Subject: LU/251/19/HH - [REDACTED]

With regard to the above application, I understand the determination date is due 3rd October. Is it possible to substitute the following drawings at this late stage?

0270 / 102 rev C	Proposed floor plans
0270 / 103 rev C	Proposed elevations

client	project	drawing	date	drawn	drawing no	revision
Stephen Hill	Extension at 13 Peregrine Road Littlehampton, BN17 6DT	Proposed plans	Mar 19	pd	0270 / 102	C
			scale 1:100 @ A3	CAD file name:

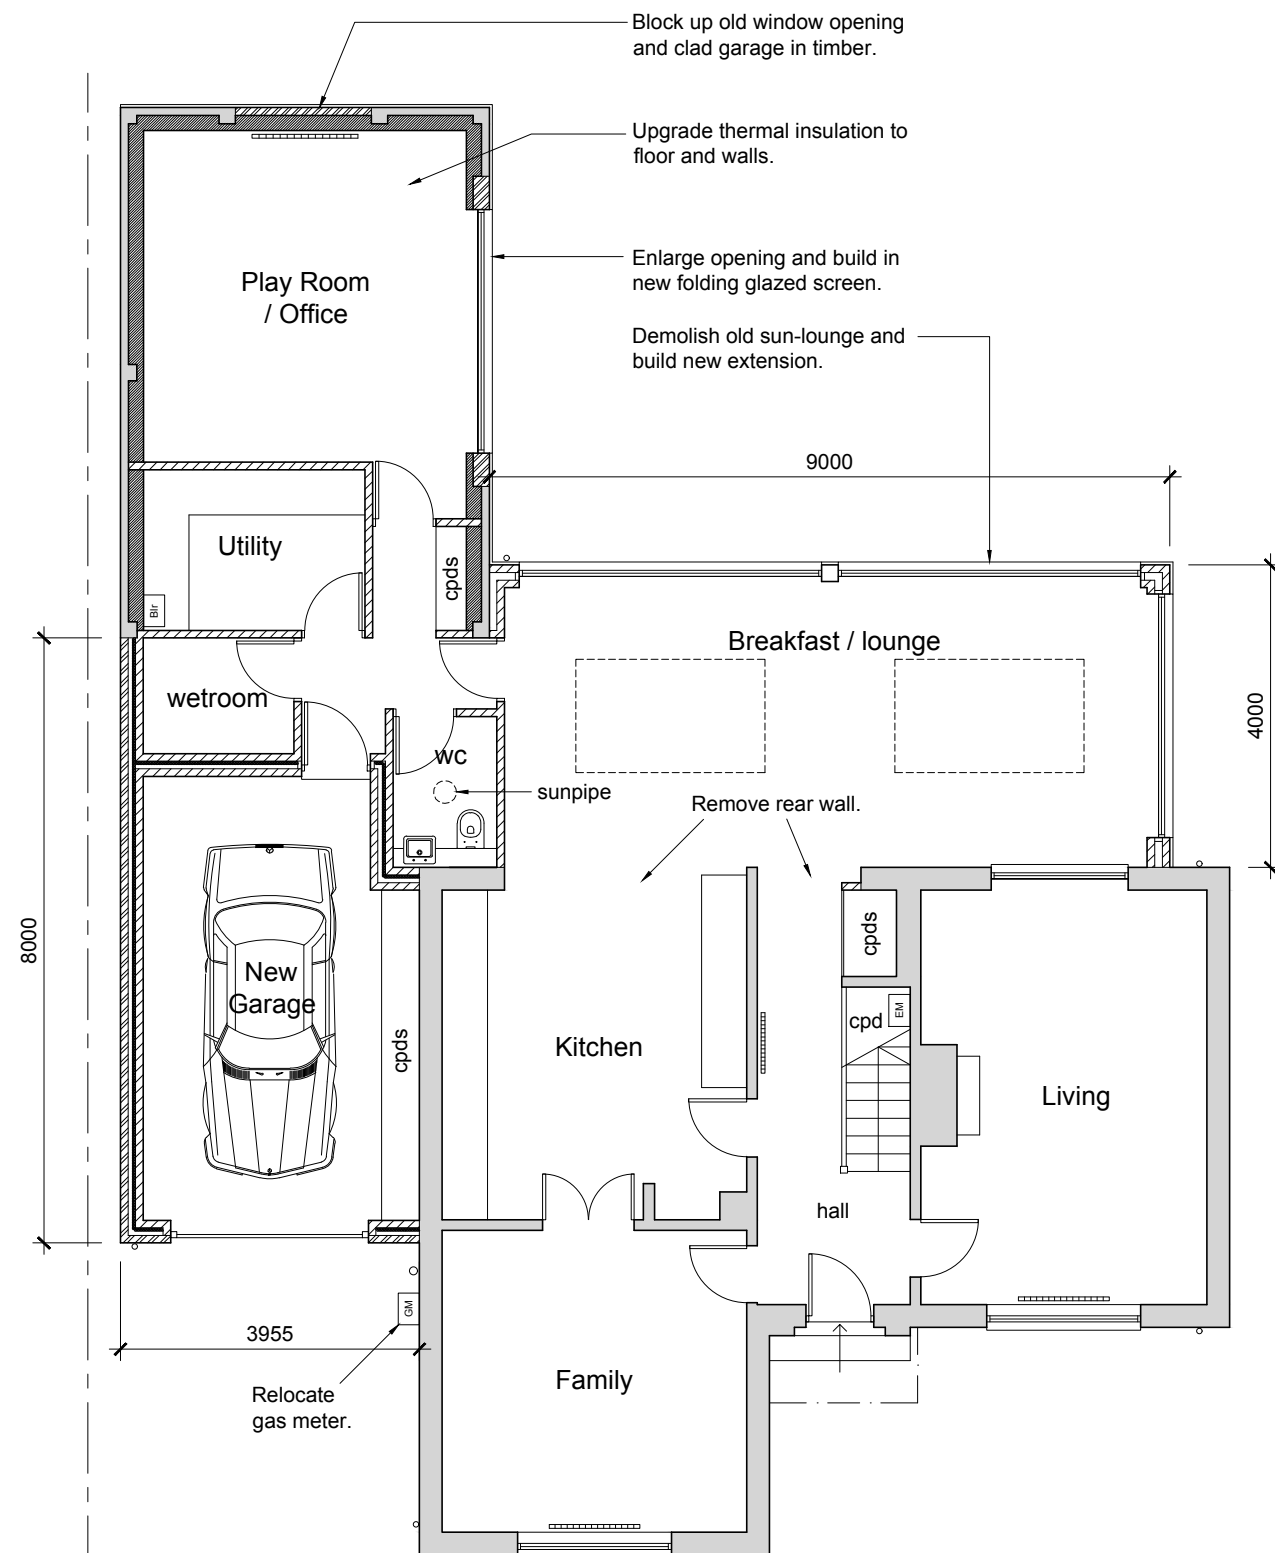
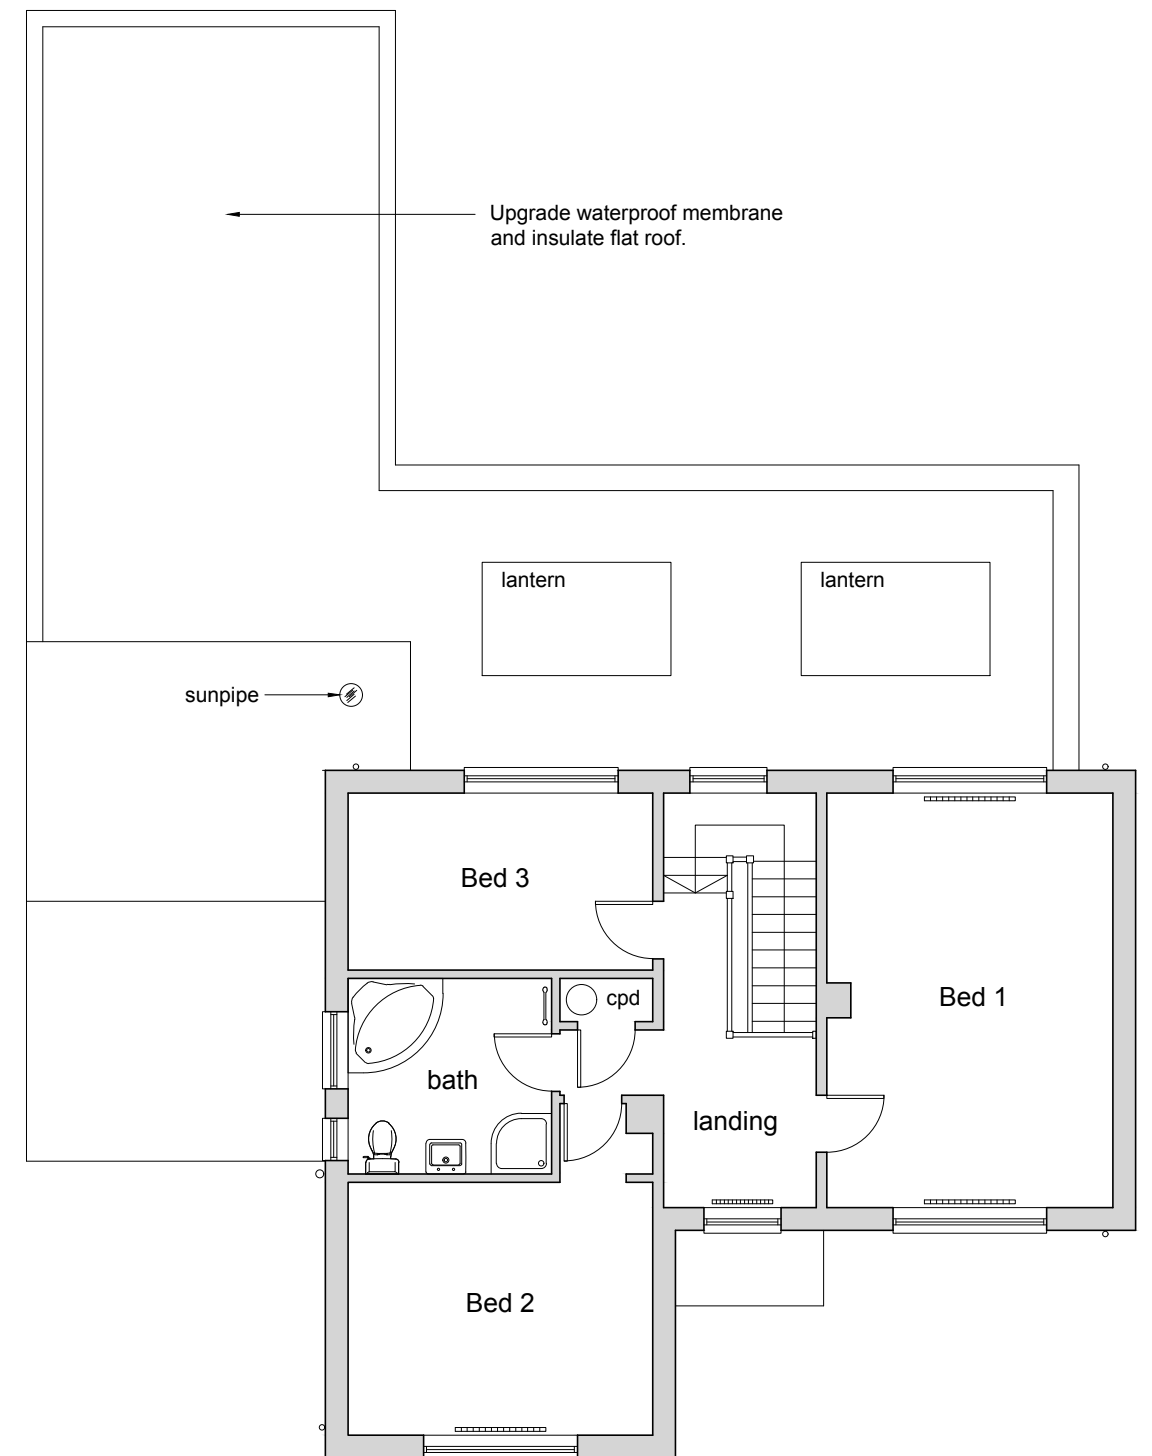
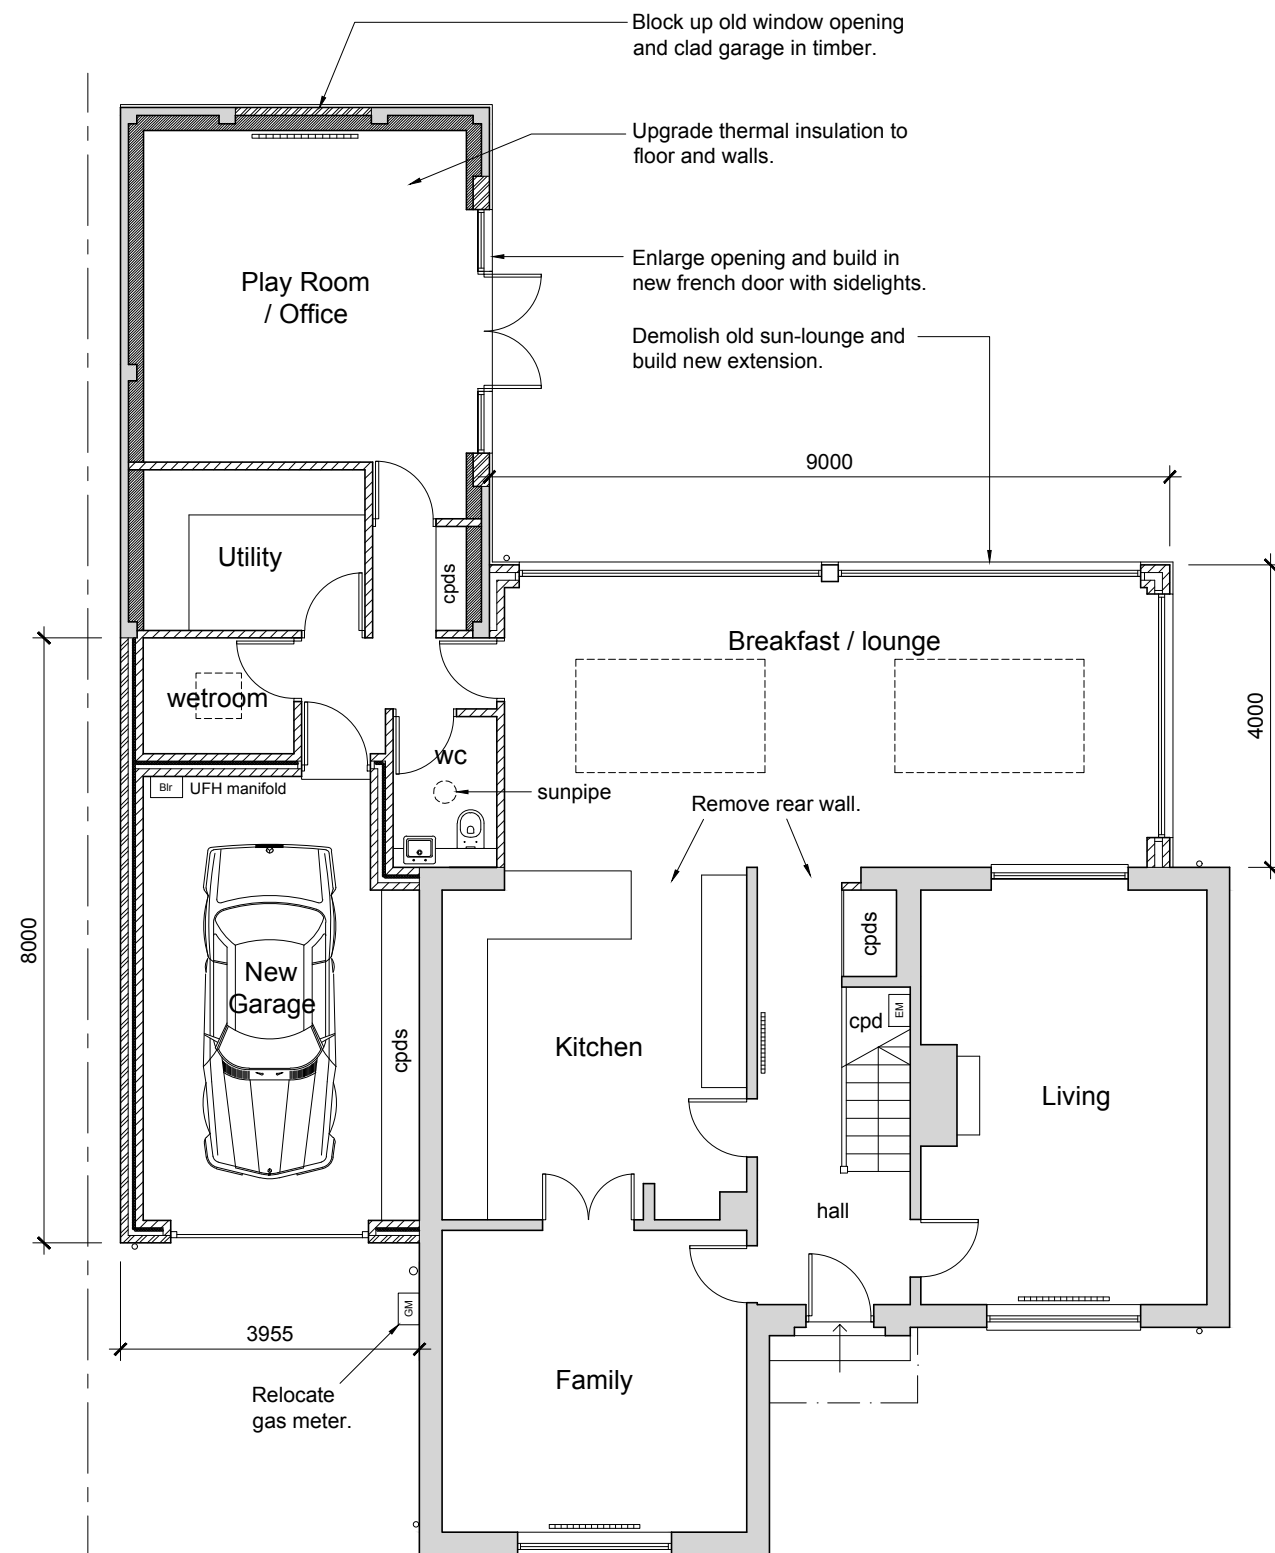
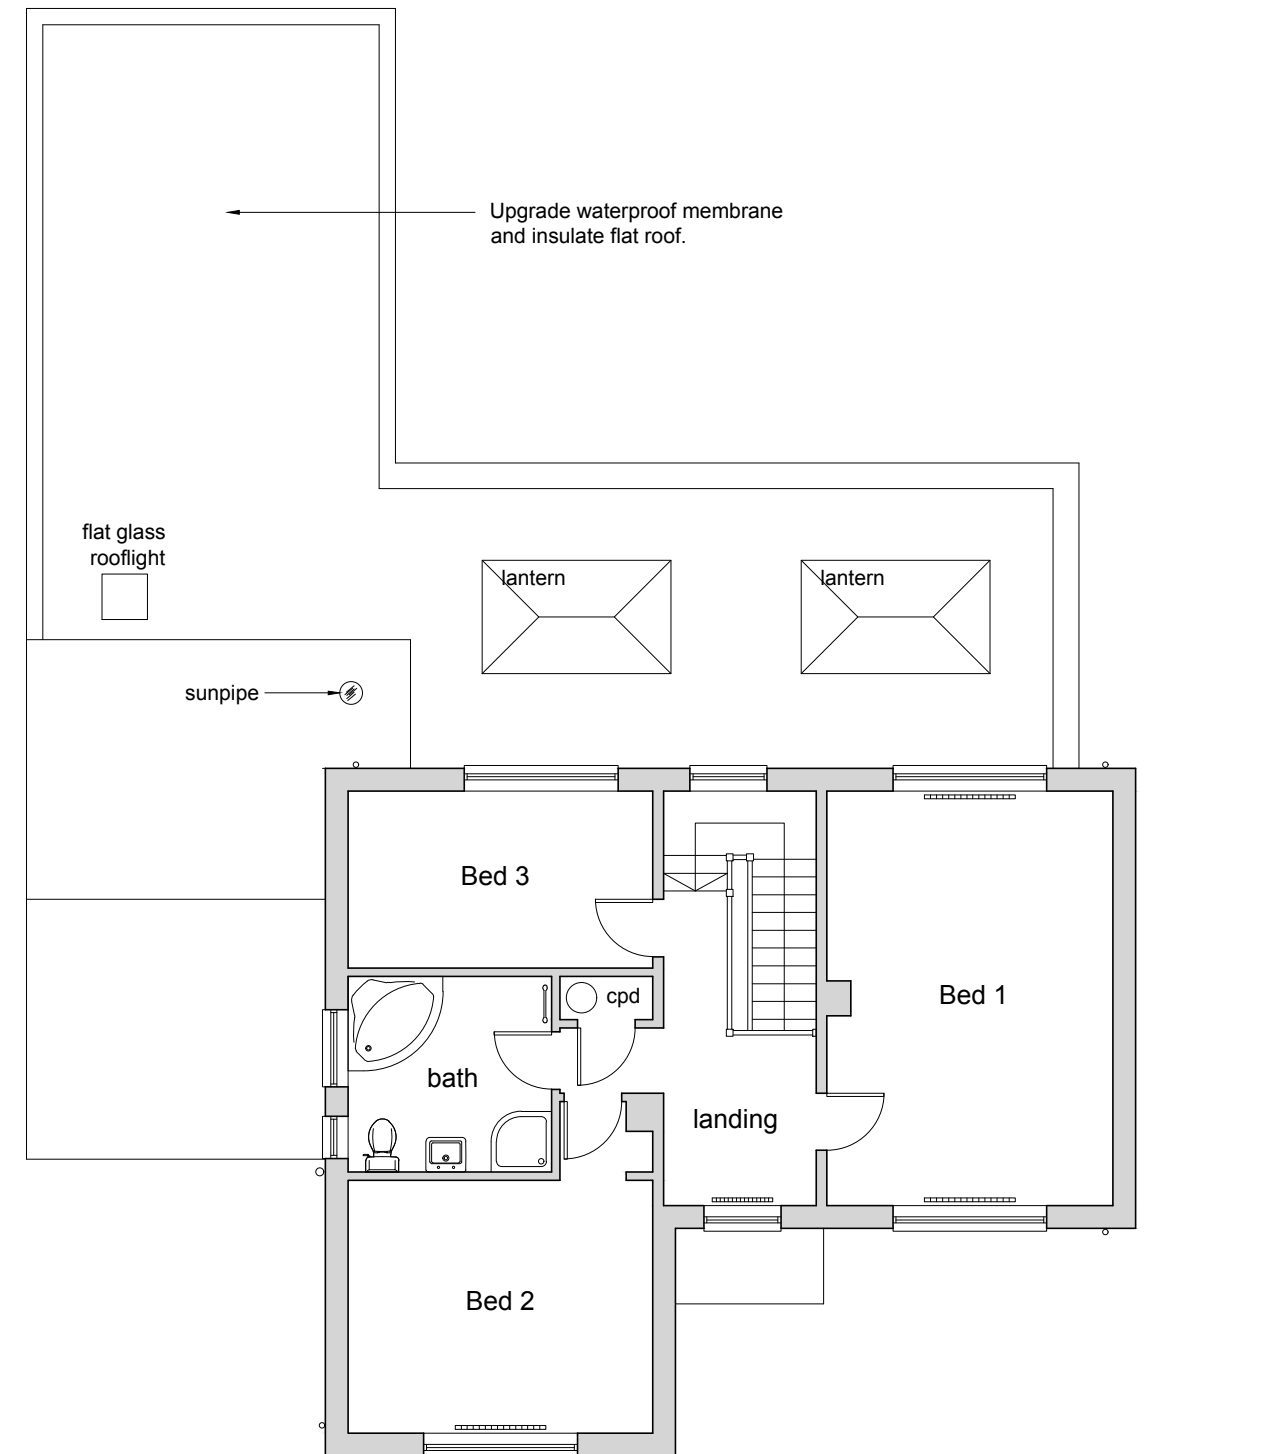
1. Flat glass rooflights changed to traditional lanterns (size unaltered).
2. Small flat glass rooflight added to the Wetroom.
3. Playroom doors changed from folding screen to french doors.
4. Garage door material changed from cedar to blue composite to match existing front door.
